Our Ref: FG/217/18/HH
Your Ref:

Town & Country Planning Act 1990 (as amended)
Town & country Planning (Development Management Procedure) (England) Order 2015
Application for Planning Permission for Works or Extension to a Dwelling

Development Rear single storey extension and alterations to roof to facilitate loft enlargement including increase to ridge height
Location 3 Lamorna Gardens Ferring

NORTH

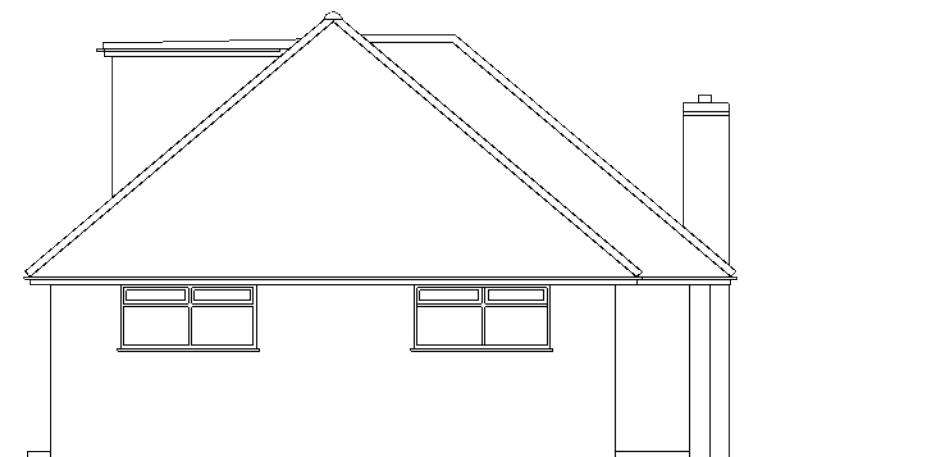
Elevation: The dormer would be visible on the proposed north elevation. Please amend accordingly.

BLOCK PLAN 1:500 @ A4.
27/11/18.
DRAWING No. DS/LAMORNA/07/REV 1.

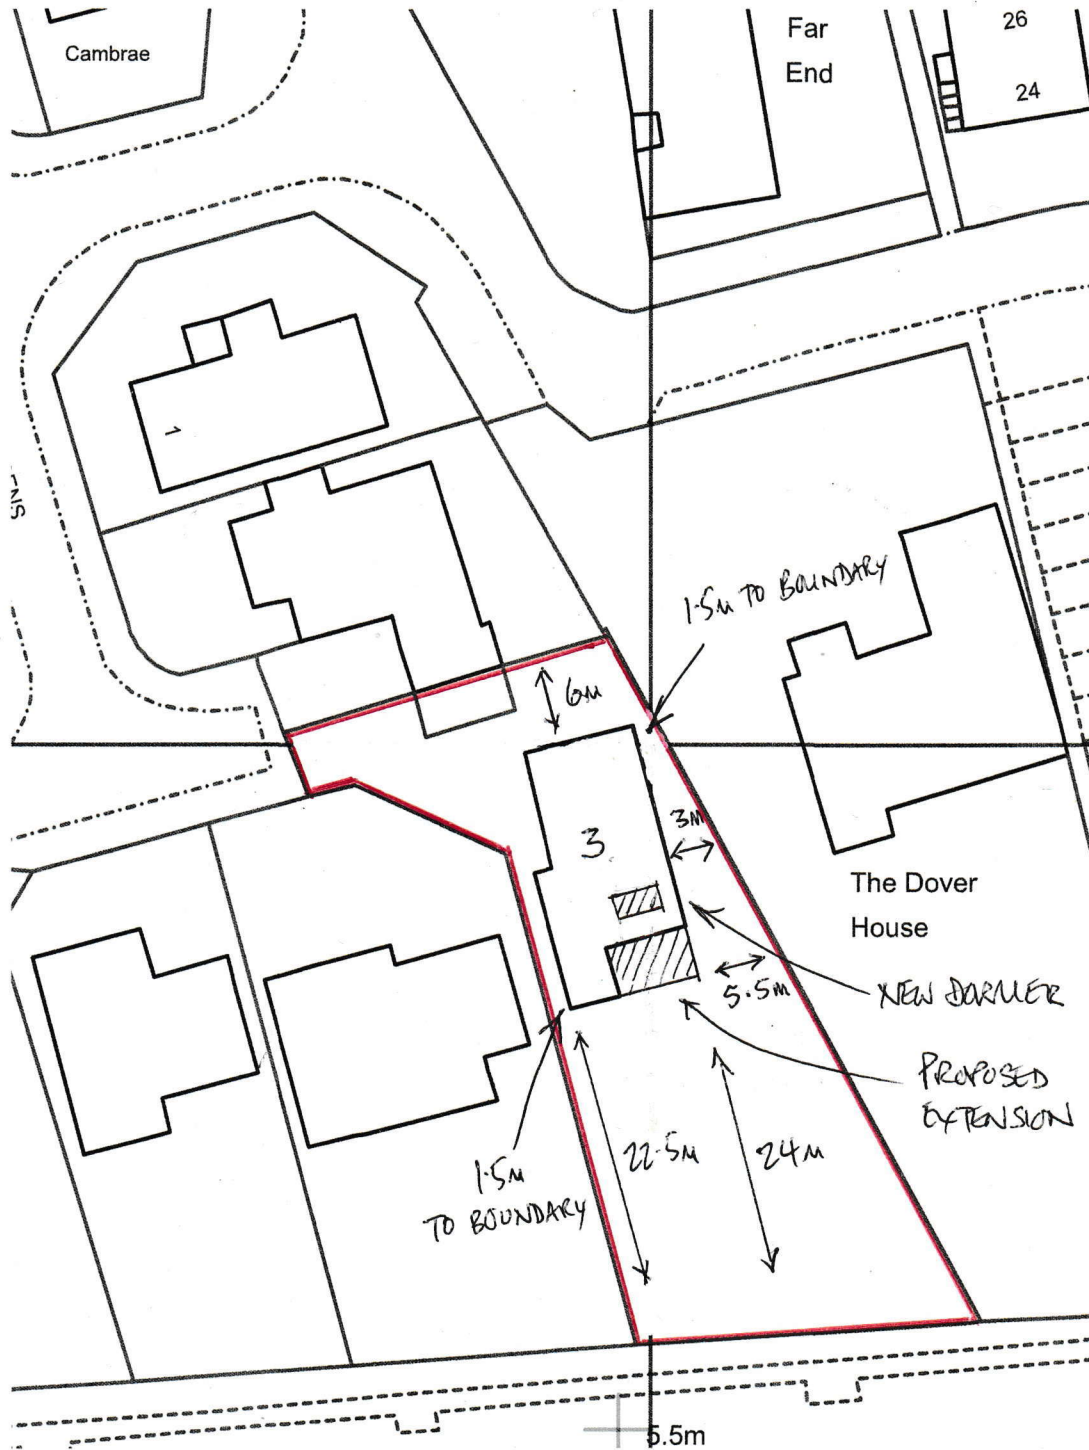
Block Plan

Please submit 1 electronic or 3 paper copies of a block/site plan which includes all dimensions from the proposed extension(s) to the site boundaries at a scale of 1:500 or 1:200. Further details of what must be included on the plan can be found in the National Validation Requirements.
